From:
To: [DCAdmin](#)
Subject: 2023/91405 - part of former Luke"s Hospital site HD4 5RA
Date: 01 June 2023 20:31:28

I live on Chapel Terrace, HD4 5DZ and write in follow up to the application 2023/91405.

drawing title
Proposed Site Plan

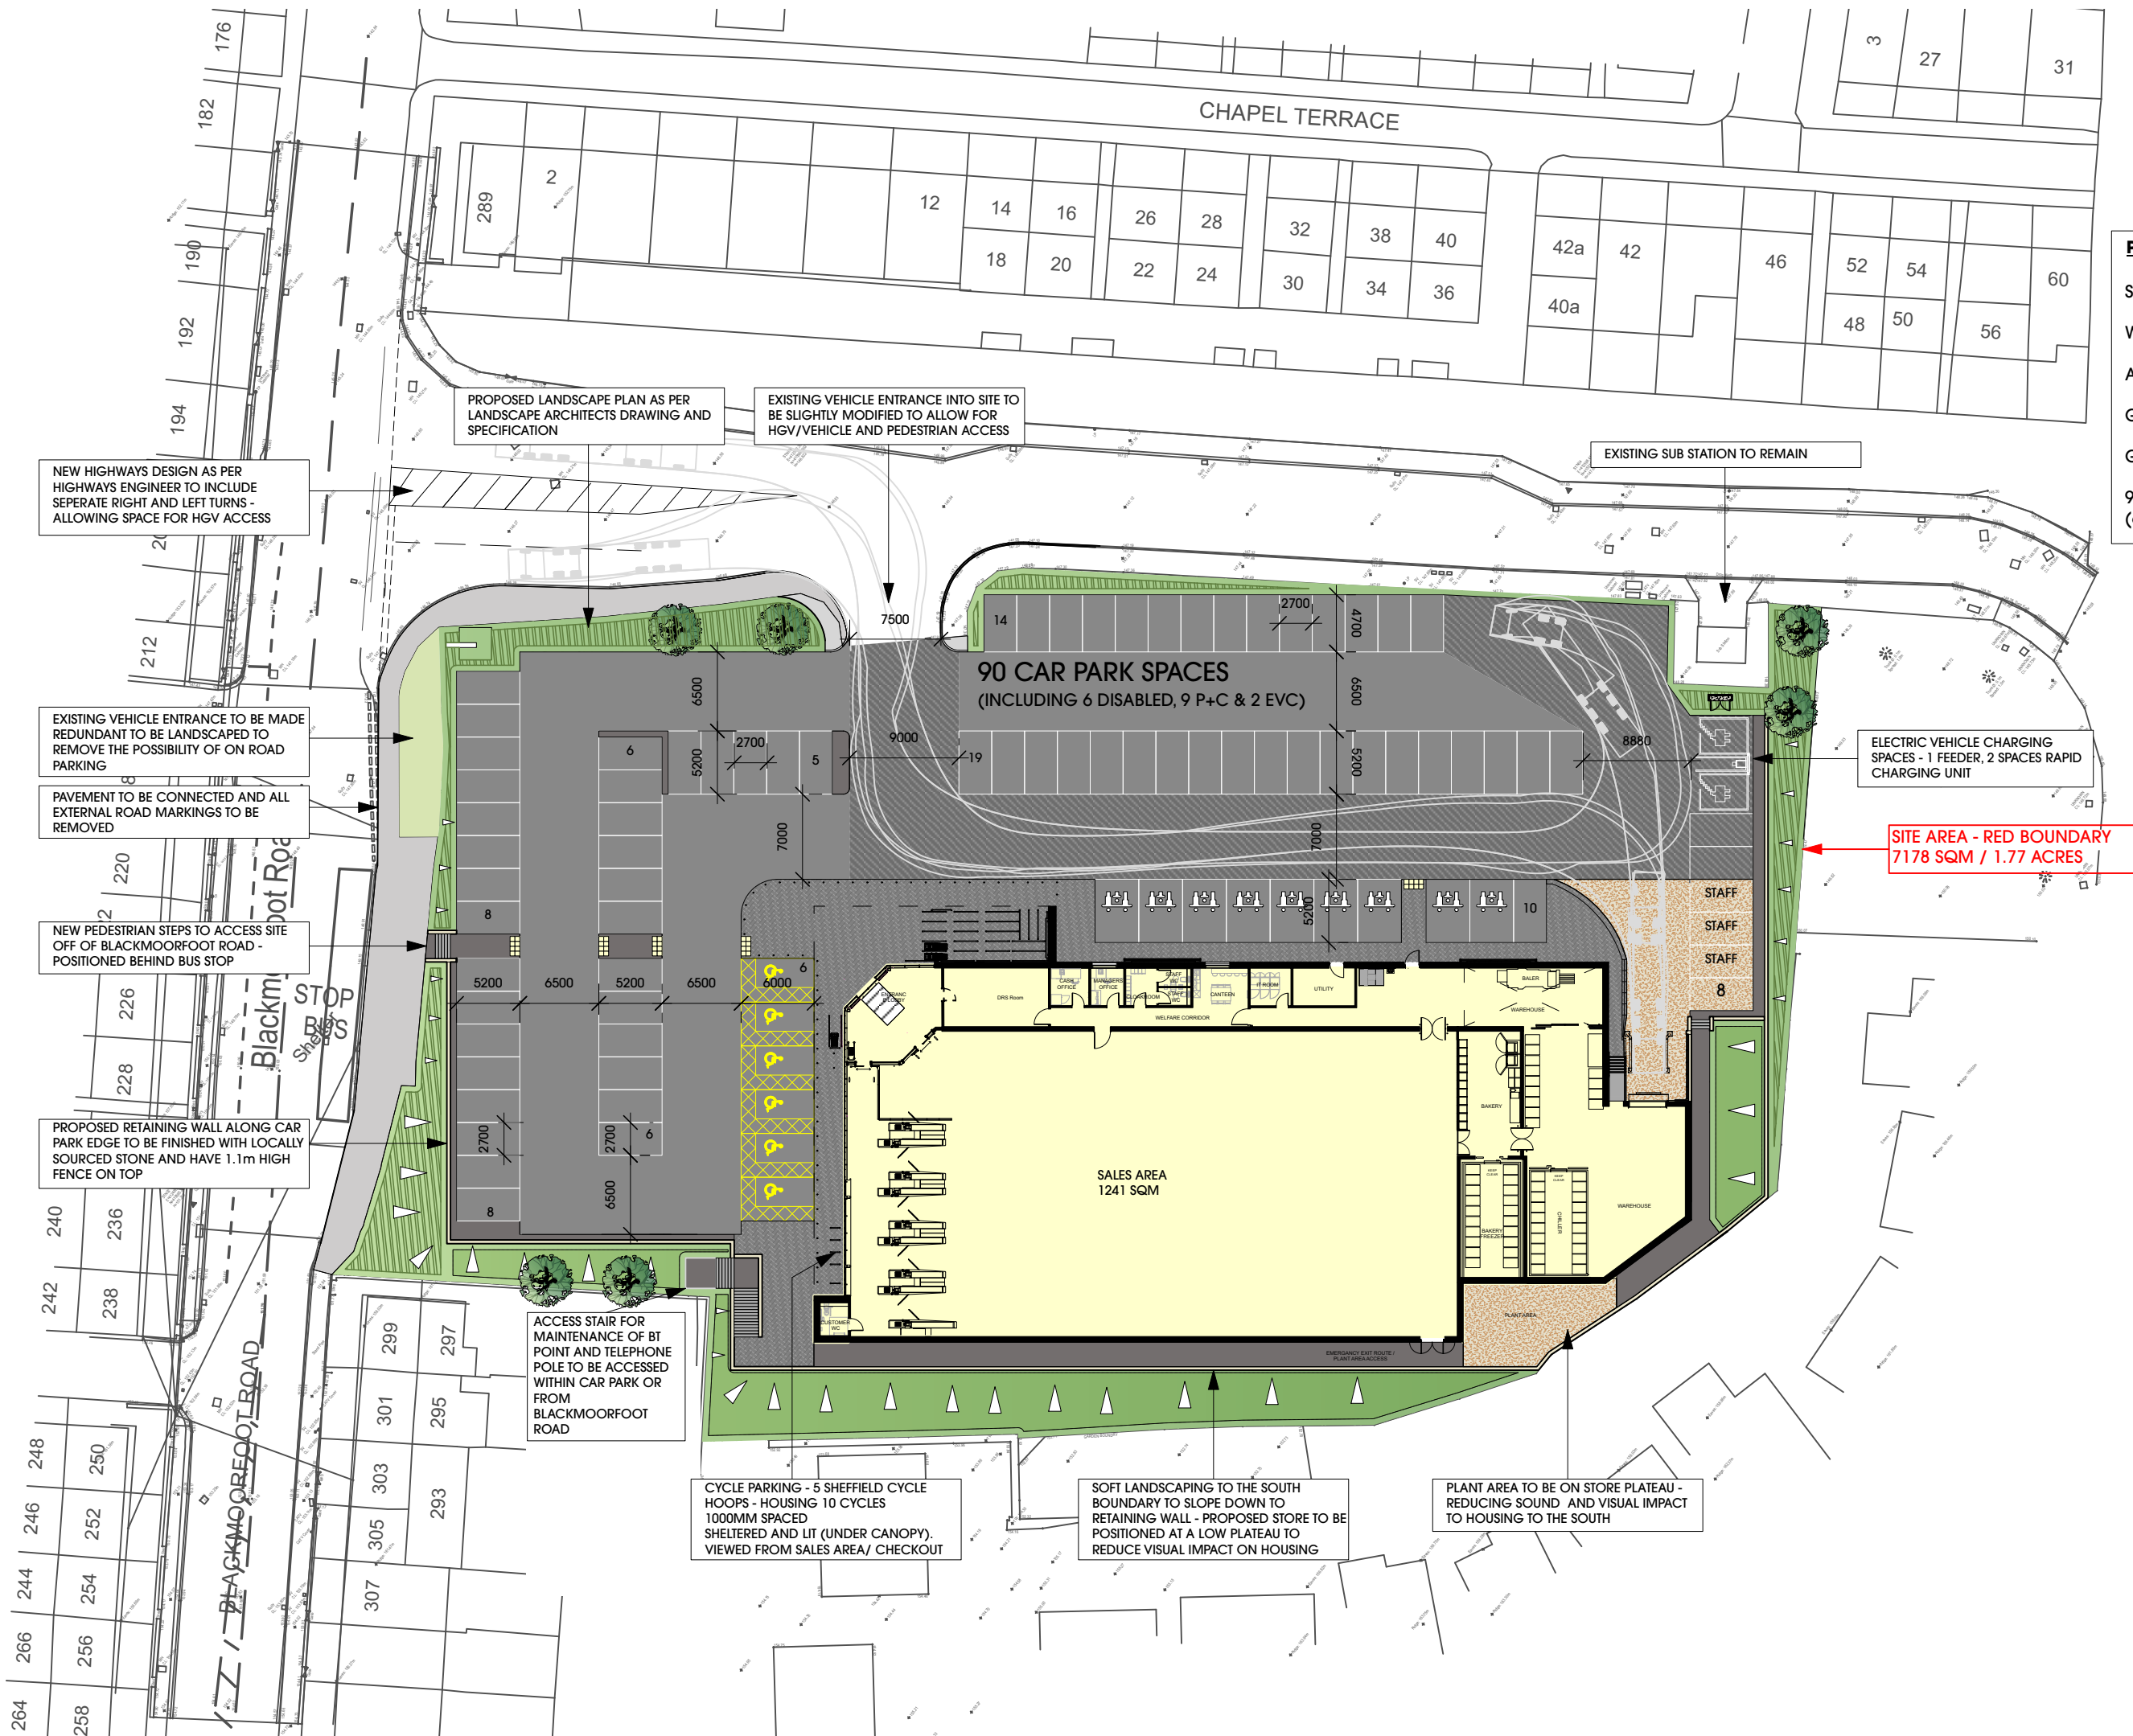
1. I know clearly that the Lidl deliveries can be at any time of night/day. The retail delivery area (service area) is close to my house, I do not want deliveries to disturb me and/or delivery noise during night times. Since all sides of the store are residential, I suggest deliveries only come in daytime hours.
2. Please can there be provision to prevent anti-social behaviour at night in the car park, eg by locking a gate or designing the car park to stop car racing.
3. Please can attention be made to increases in traffic along Blackmoorfoot Road, eg by providing traffic calming, improving zebra crossing visibility and such.
4. Design of store, I hope the store adequately blends in and is low level. And as such does not affect natural light to Chapel Terrace.
